FORMAL OBJECTION TO SSD-85464245

Mixed Use Development – 4–4A Flinders Street, North Wollongong

Re: Formal objection to SSD-85464245 – Mixed Use Development, 4–4A Flinders Street, North Wollongong

1 SHADOW PLAN - 21/06/2025-9.00
1 : 3000

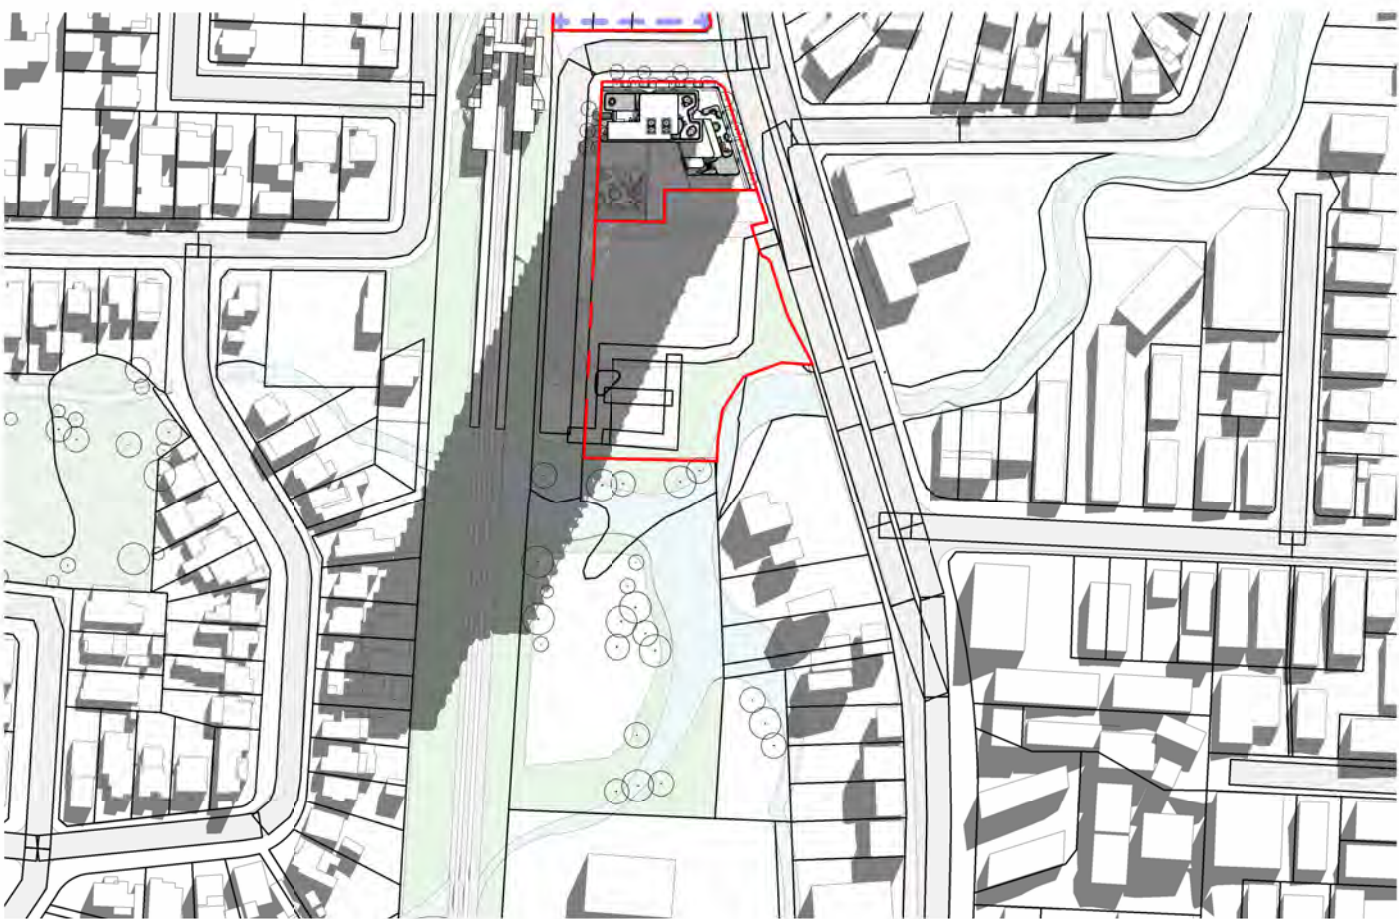
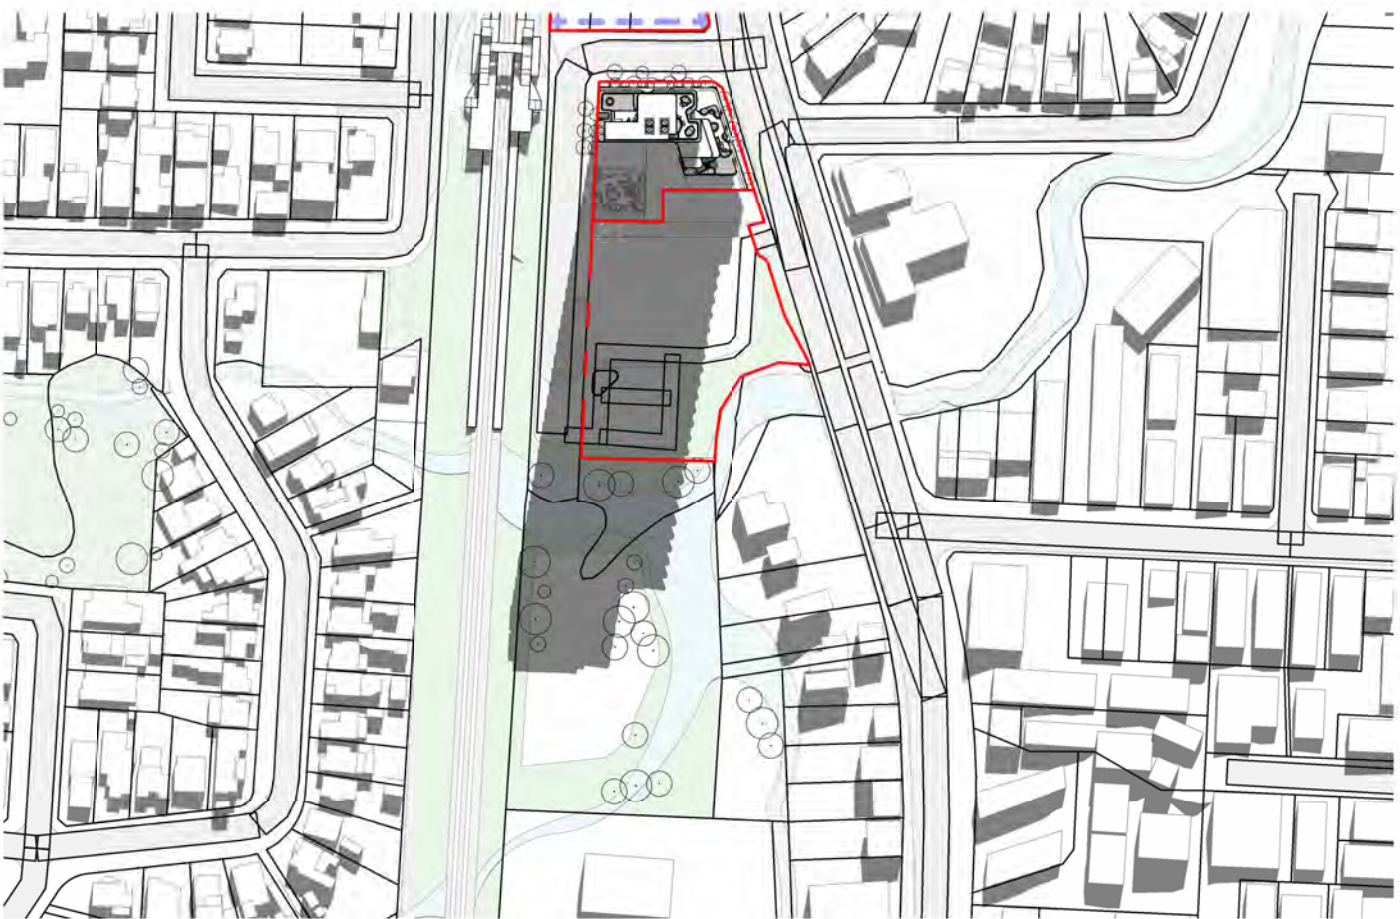
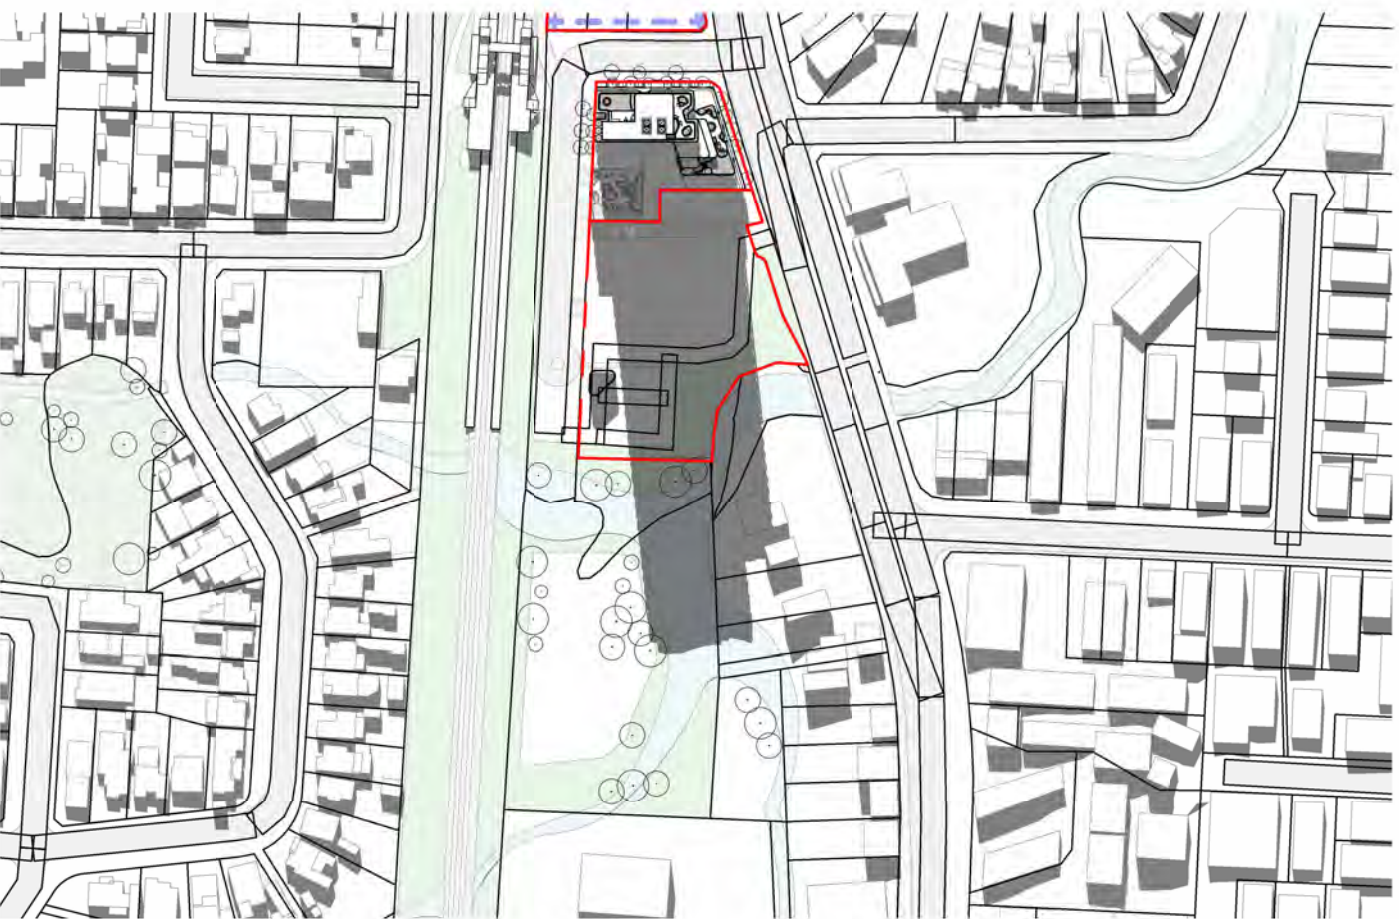
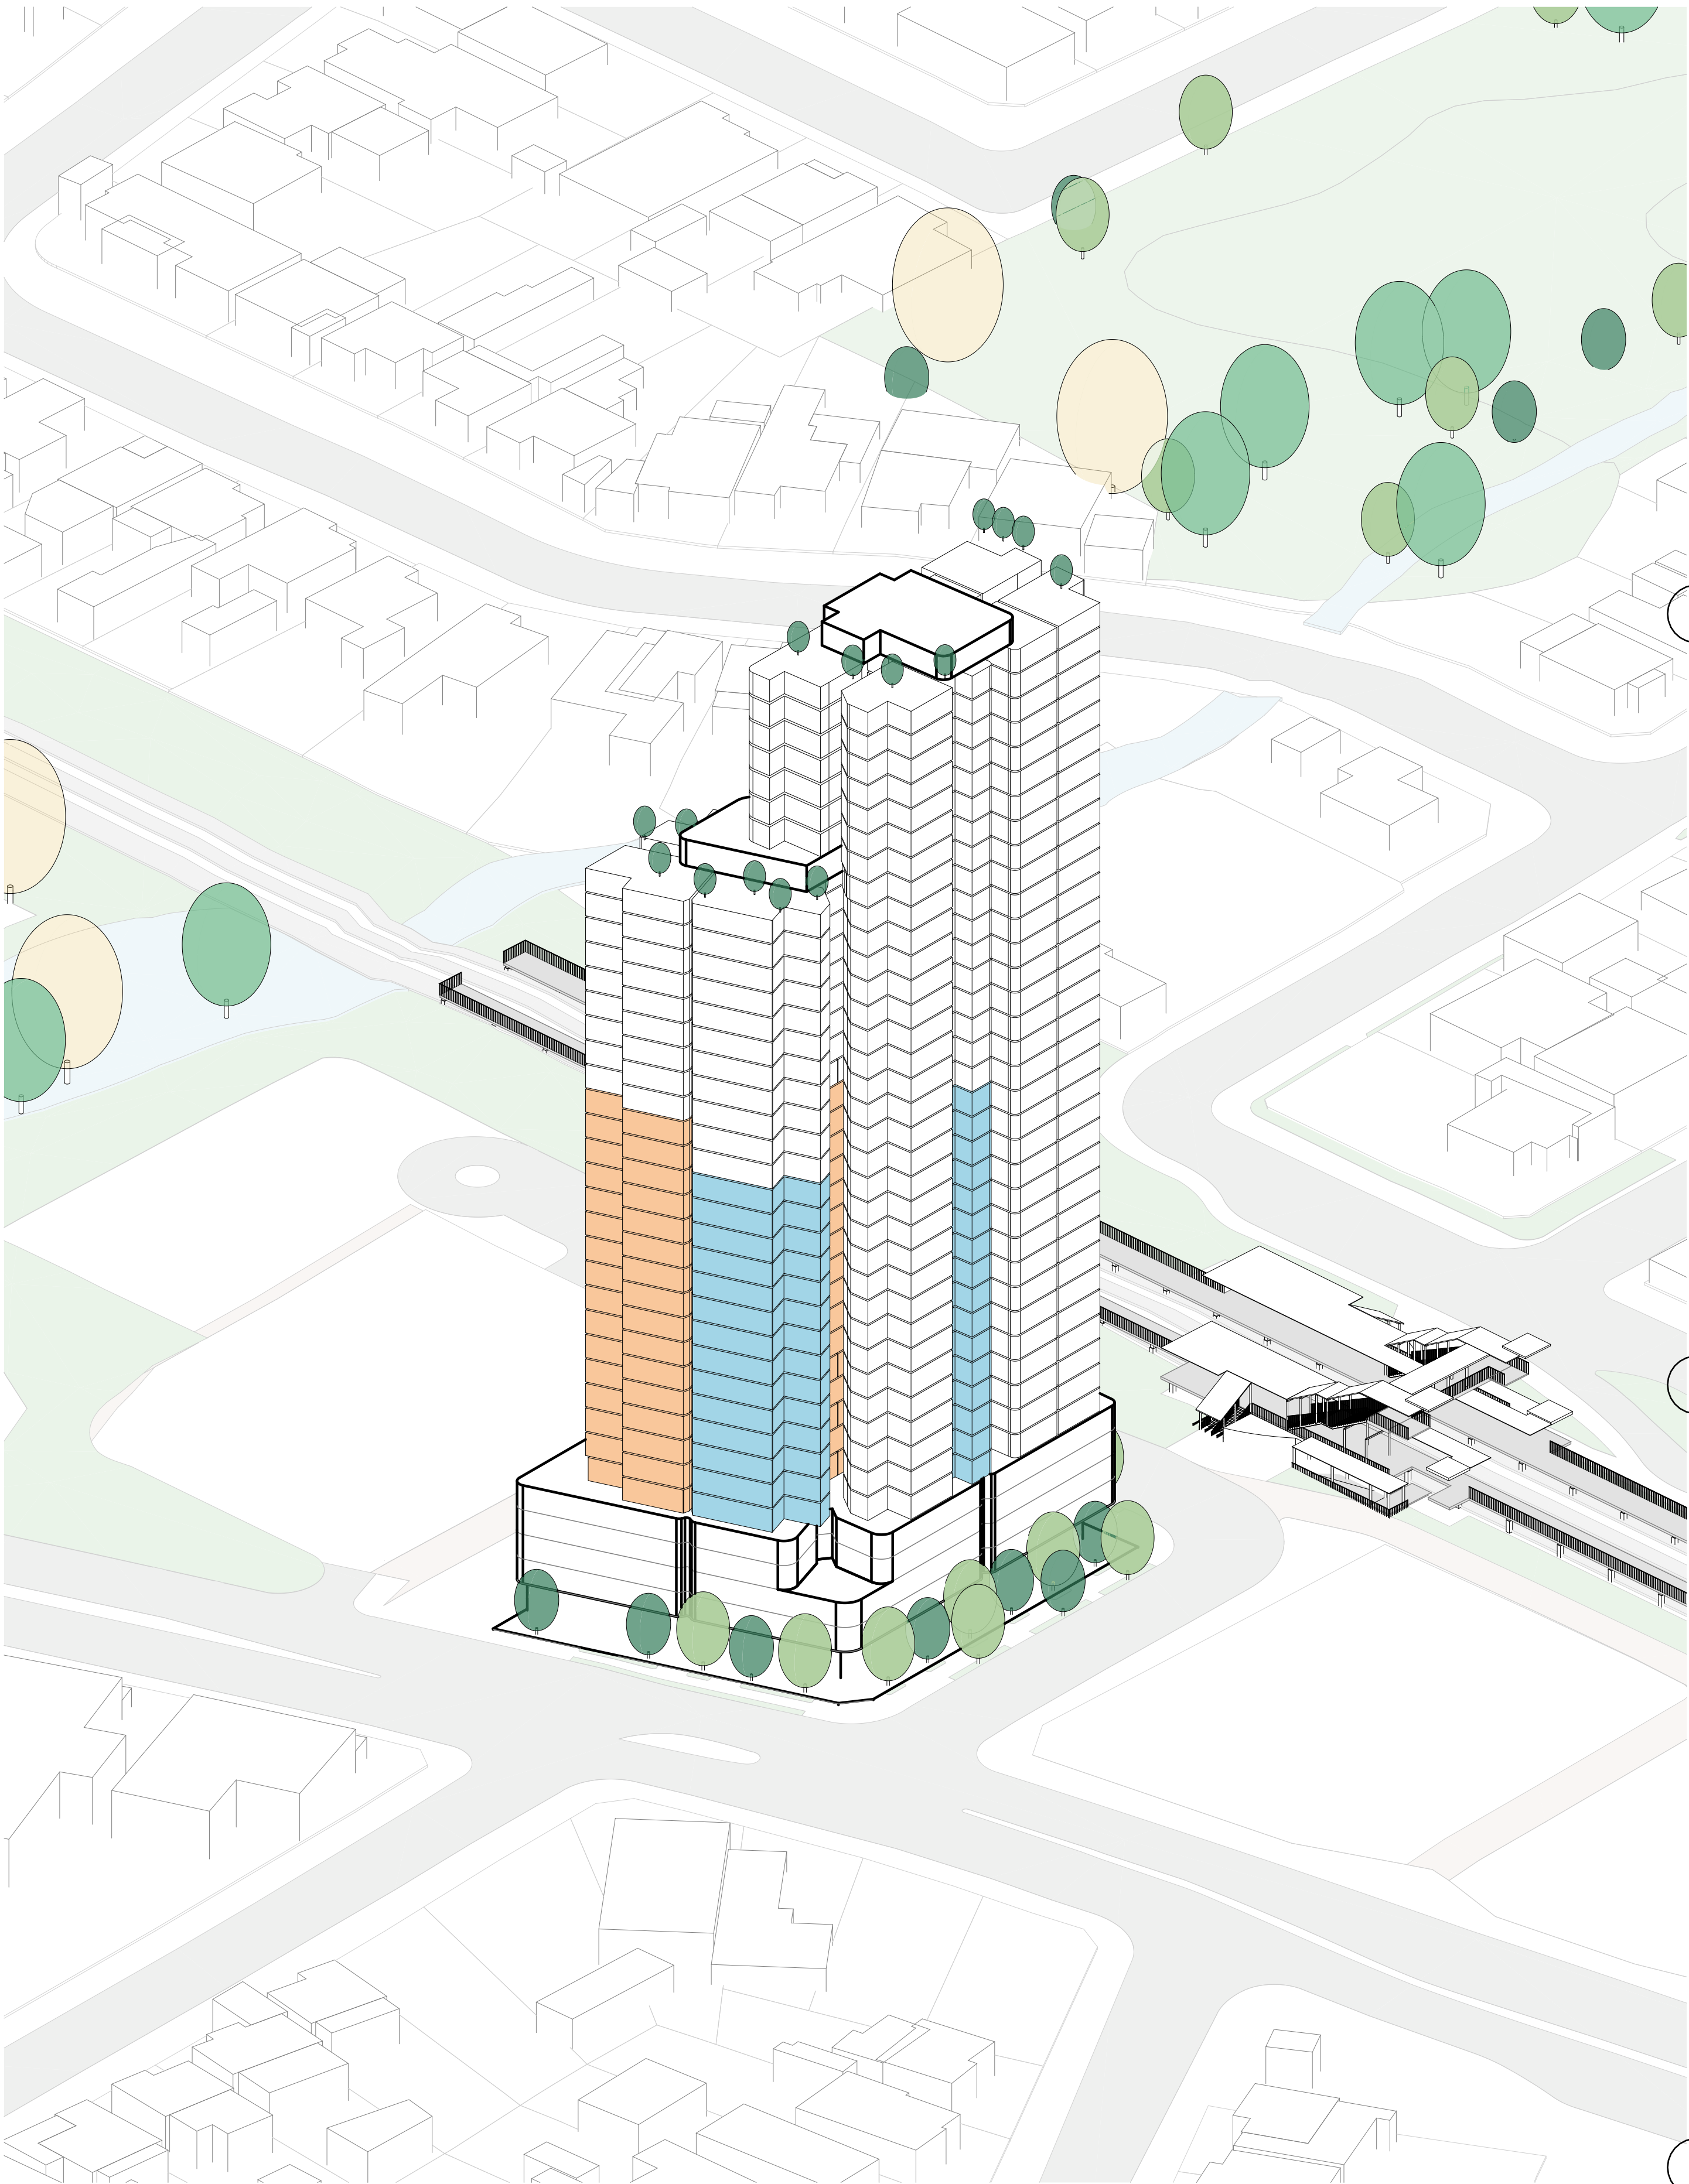
The Applicant's material does not presently demonstrate that the proposal has adequately addressed the specific impacts on **Crawford Avenue, Gwynneville**. In particular, there does not appear to be a property-specific analysis confirming whether the proposed tower will overshadow my dwelling, private open space, roof areas or solar access enjoyed by my property.

This is a material deficiency. A development of this height and scale has the capacity to cast extensive shadows, particularly during winter. The development should not be approved in the absence of clear, accurate and property-specific analysis of overshadowing and solar access impacts on nearby residential receivers, including my property.

The Applicant should be required to demonstrate, through accurate and independently verifiable shadow diagrams and solar access analysis, whether the proposed development will cause overshadowing to:

- habitable room windows;
- private open space;
- rear yard areas;
- outdoor living areas;
- roof areas;
- any existing or reasonably expected solar access; and
- any existing rooftop solar infrastructure, if applicable.

In circumstances where the Applicant has not provided a property-specific assessment of the overshadowing impacts on my property, the application has not demonstrated that the development satisfies the relevant solar access and amenity objectives.

Notwithstanding those deficiencies, the shadow material referred to in the existing submission indicates that the proposed development will cast extensive shadows beyond the subject site during winter months.

4. require accurate hourly shadow diagrams for relevant periods, including winter conditions;
5. require quantitative solar access analysis for affected residential properties;
